From: Joe Gilbert
Sent: Monday, September 17, 2012 3:43 PM
To: Jeff Watson
Subject: RE: BL-12-00023 Jones

**BOUNDARY LINE ADJUSTMENT**  
 PREPARED FOR  
 JOYCE JONES  
 A PORTION OF THE SE 1/4 OF SECTION 22,  
 TOWNSHIP 20 NORTH RANGE 14 EAST, W.M.

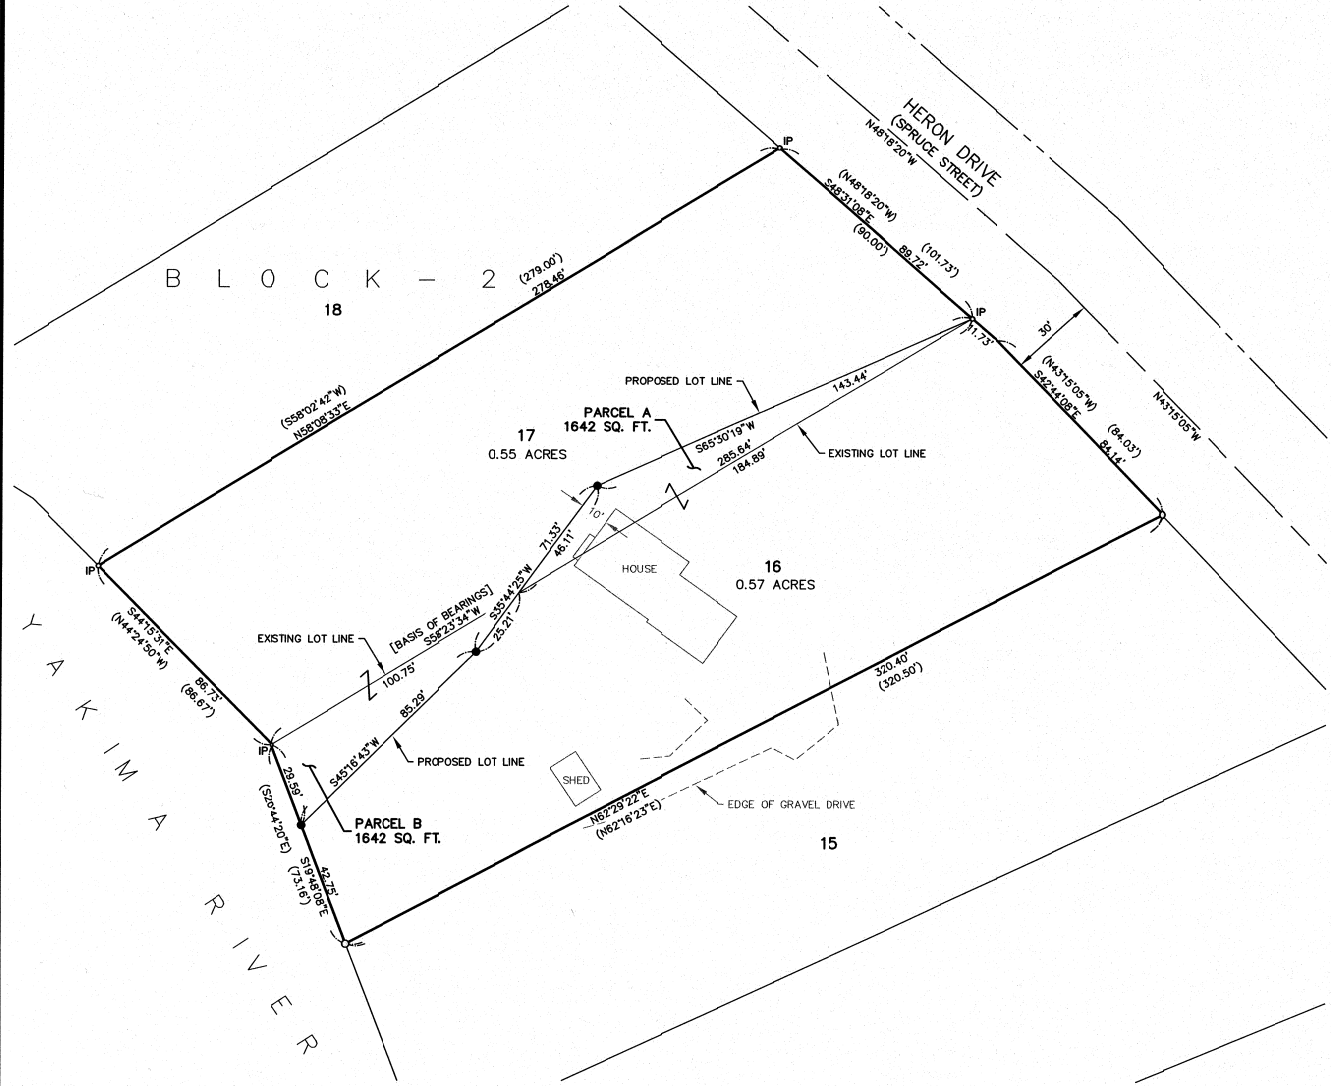
In reviewing this application I have some question as to where the existing drainfield is in relationship to the proposed lot line. I pulled up an as built that shows the two, 30 foot drain field lines being located between the house and the shed somewhere and need to verify that the setback from the property line to the drain field lines is met.

After reviewing the updated site plan and plat map, please continue processing this application as is. I have field verified the sporadic septic system and reserve area, and it does meet setbacks from new property lines.
